Application for a non-material amendment following a grant of planning permission.

Erection of three detached dwellings Land at Old Lane / Tylor Lane, Scapegoat Hill, Huddersfield HD7	
Reference number:	2015/62/92476/W Approved on appeal
Date of decision	10/05/2017

6. Non-Material Amendment(s) Sought

Client:	BRIERSTONE
Job:	Scapegoat Hill, Golcar
Drawing title:	Plot 2 - Layouts - First and Roof Plan
Drawing Number: (Job number)	M4724-2 20 02
Scale:	1 : 50 @ A1
Date:	12.11.2020
Drawn by/ checked by:	CS

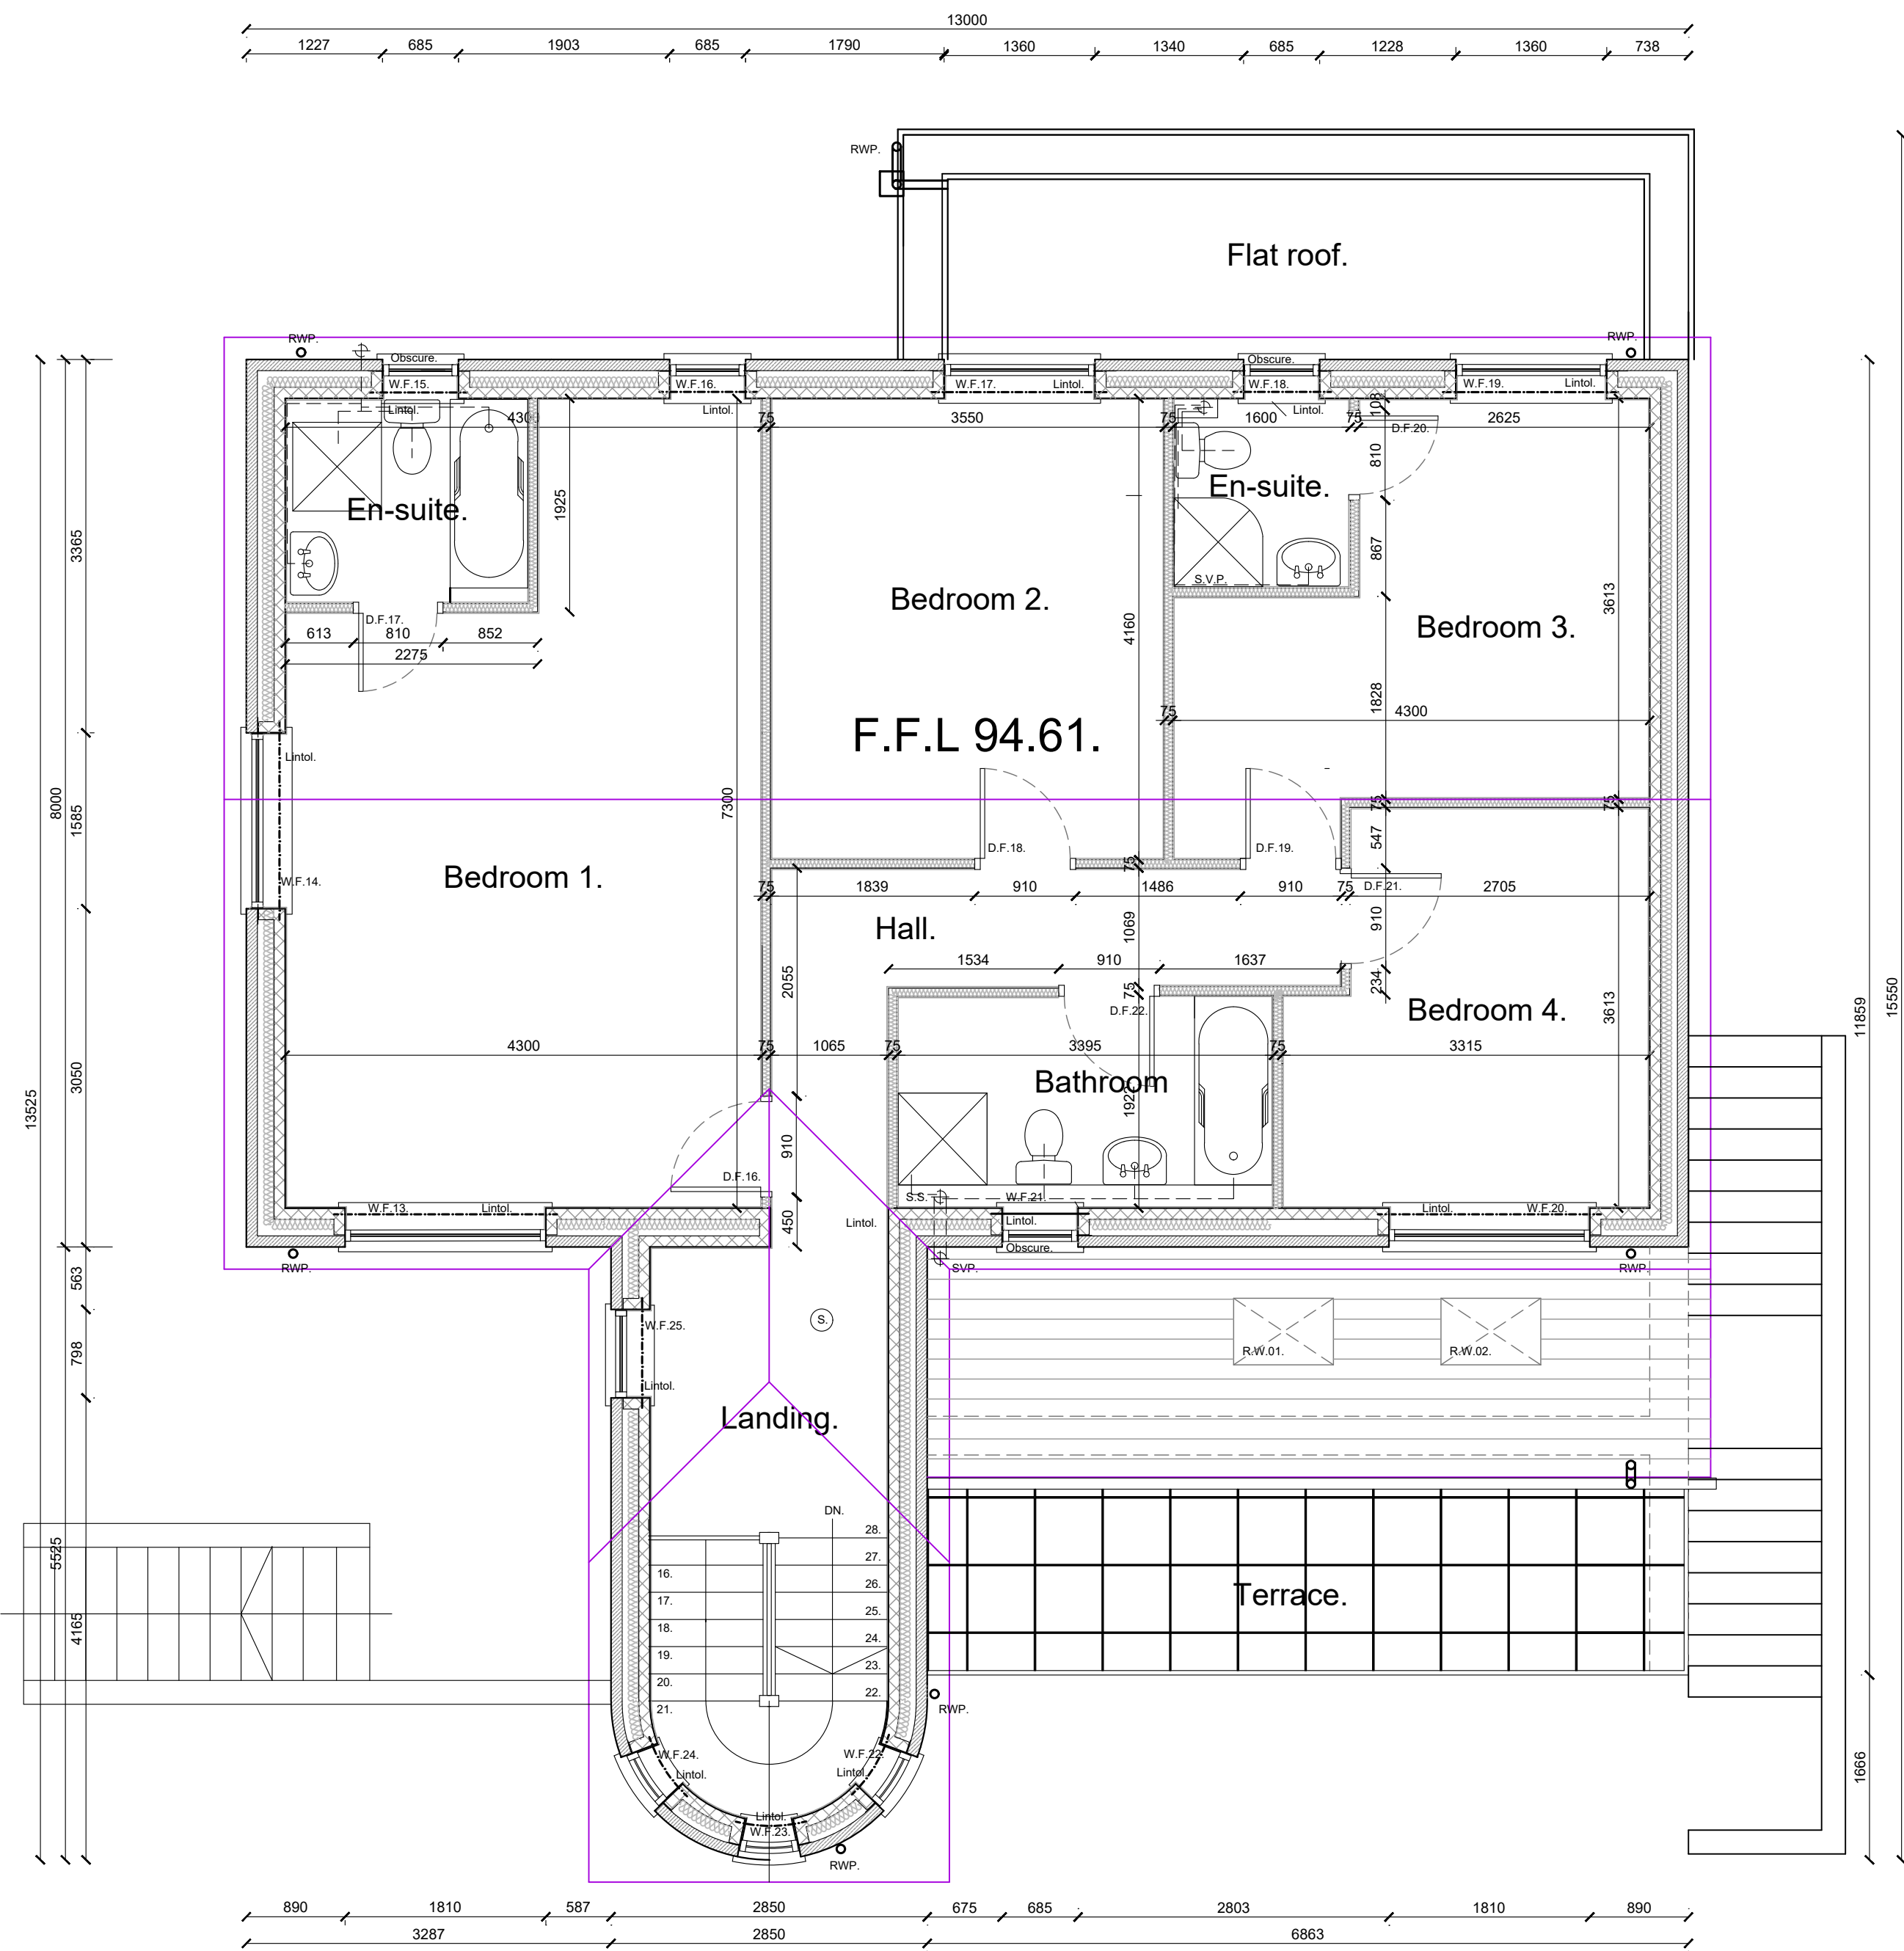
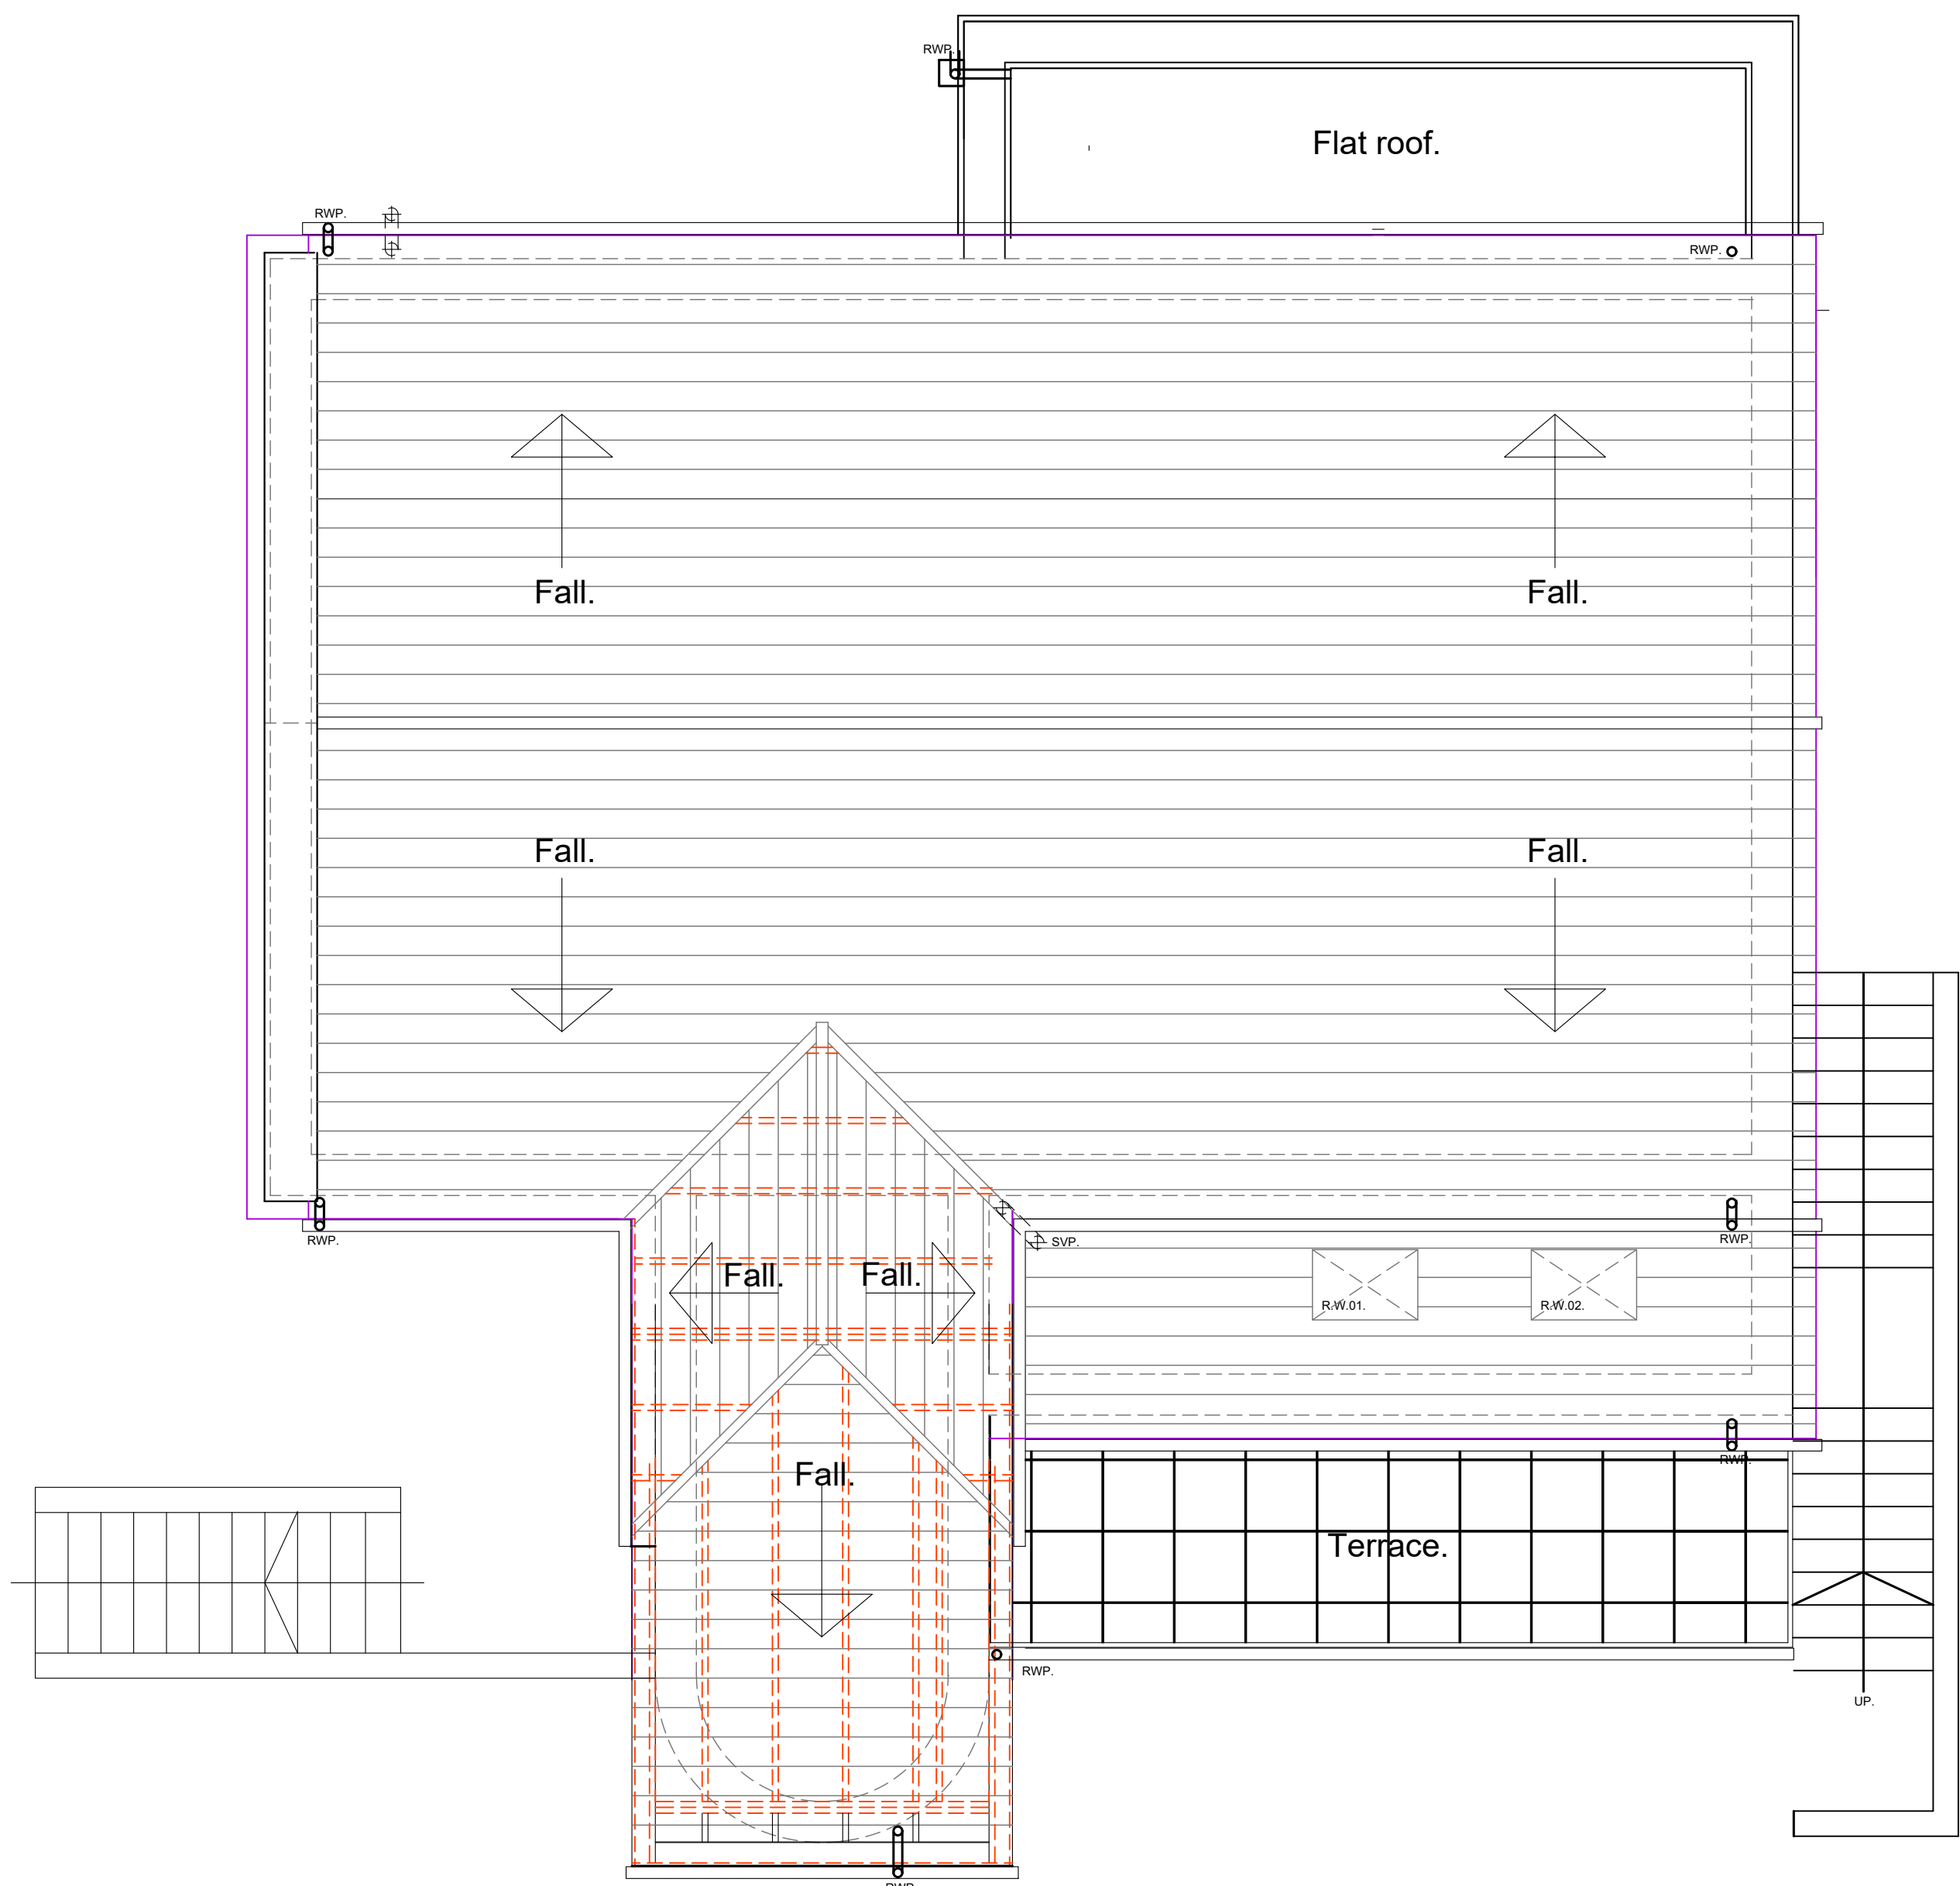
- Removal of lift
- Additional windows to utility / kitchen
- Removal of rooflights to kitchen
- Window added to ground floor WC
- Conservatory amended to incorporate within kitchen / terrace
- Patio doors added to lounge in-lieu of window
- Juliet balcony amended to window to first floor
- Alterations to rear elevation first floor
- Alterations to roof
- Alterations to fenestration of windows to staircase structure
